AQUIND Interconnector

Application by AQUIND Limited for an Order Granting Development Consent

Deadline 2 responses

Havant Borough Council

Aquid Countryside Option

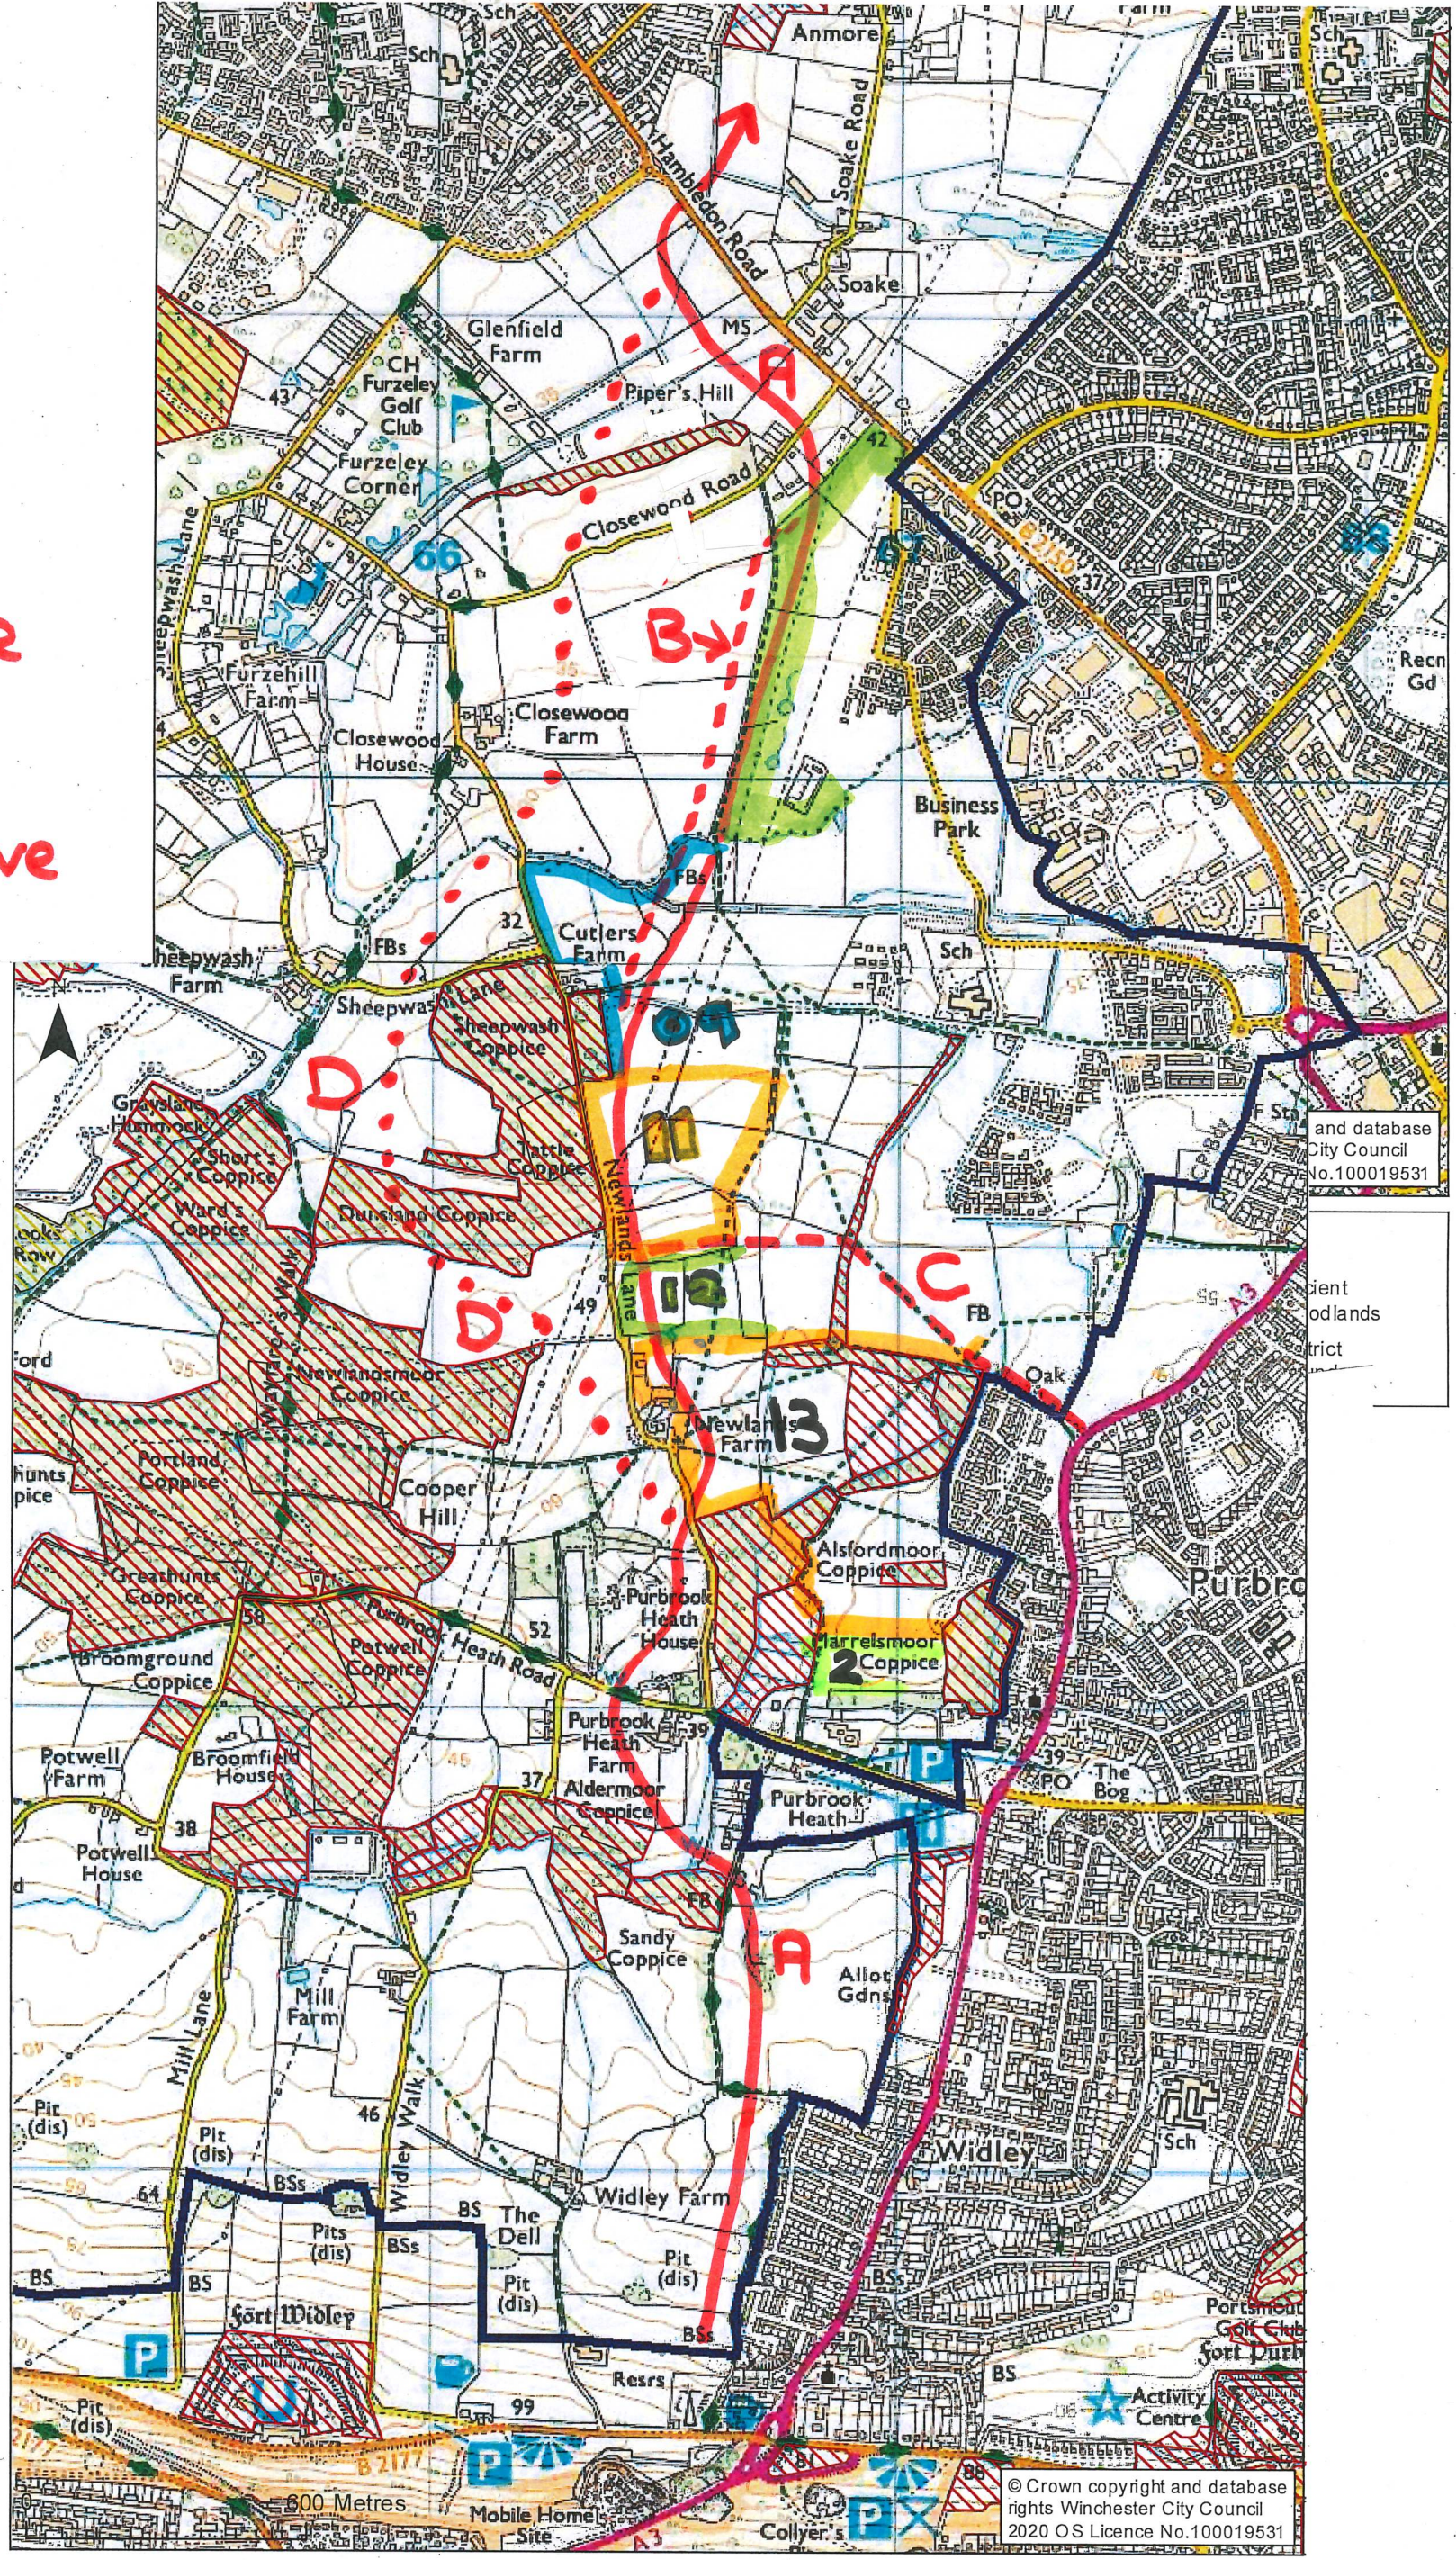
4. The Supplementary Alternatives Chapter, specifically chapter 8 – Countryside Route (doc ref 7.8.1.3), outlines many reasons why the applicant has discounted this route. However, no indications of dates of when this potential route was considered have been provided. From the reading of the document many of these arguments have been retro-fitted to conclude that the highway route is the chosen, without full due consideration of this route in detail.

5. Regarding the ecological impacts of this proposed route for HBC's alternative route considered from paragraphs 8.1.4, as has been highlighted HBC are not the Local Planning Authority for the area and did not have access to the level of information required to consider this route in detail. Winchester City Council's route is more informed as they are the LPA for the area, with this route being considered by the applicant in paragraph 8.1.5. It is noted that in paragraph 8.1.5.5 that no fieldwork surveys have been undertaken to consider the presence of protected species in this area. It is stated by the applicant that their presence is known, this may well be true, however with the appropriate surveys being undertaken a route is likely to have been devised that either avoided such protected species or provided appropriate mitigation measures regarding protected ecological areas.

6. Regarding the sterilisation of land considered by the applicant in paragraphs 8.1.7. The applicant raises points that the cable routing through this area would sterilise the land for both future and current committed developments. Regarding the future of development, these areas are within the administrative boundaries of Winchester City Council. However, if any of this further land was to be allocated for housing, then policies would be given due consideration in the Local Plan process, would be in place so that if any development were to be proposed then any layout of the development would need to take account of the cable route, as such this is not a reason to dismiss this route on this issue alone.

7. Paragraph 8.1.7.3 outlines concerns that the development would adversely impact on the West of Waterlooville Major Development Area (MDA), by severing the site and being in the open space on the western part of the site. It is considered that appropriate mitigation

measures could be utilised to avoid such conflicts, indeed the route of the cable could be located to the west of the site, to avoid any such conflicts.

8. Paragraph 8.1.7.9 outlines concerns that the proposed cable routing would sterilise areas identified in the Hampshire Minerals and Waste plan, comprising soft sand (pale yellow) and brick clay (brown). With any development appropriate mitigation measure to avoid such sterilisation occurring, it is noted that no reference is made to the applicant discussing this matter with Hampshire County Council as Minerals and Waste Authority, who would provide advice on this matter to ensure that measures were in place to maintain the ability to utilise these mineral deposits.

9. Following our own discussions with the Minerals and Waste Authority, who have considered the data within the Aquind ES Addendum Appendix 3 Supplementary Alternatives Chapter. Given the relatively small areas of safeguarded minerals which the proposed routes would sterilise, and that there are no safeguarded mineral or waste sites in the vicinity of the proposed countryside routes, they cannot see a reason for an objection to either of the proposed countryside routes should they be adopted, subject to suitable controls.

15. Furthermore, this additional information indicates that many mitigation measures for the countryside could be employed, with regard to visual impact, highway and crossing of watercourses. Indeed, this route could provide some benefits by utilising the apparent sterilised land for long term public benefit. Other matters such as ecology, whilst acknowledging that any countryside route would need to consider the

impact on protected area, the routing of the cabling could be positioned in a way to either avoid or mitigate any associated impacts.
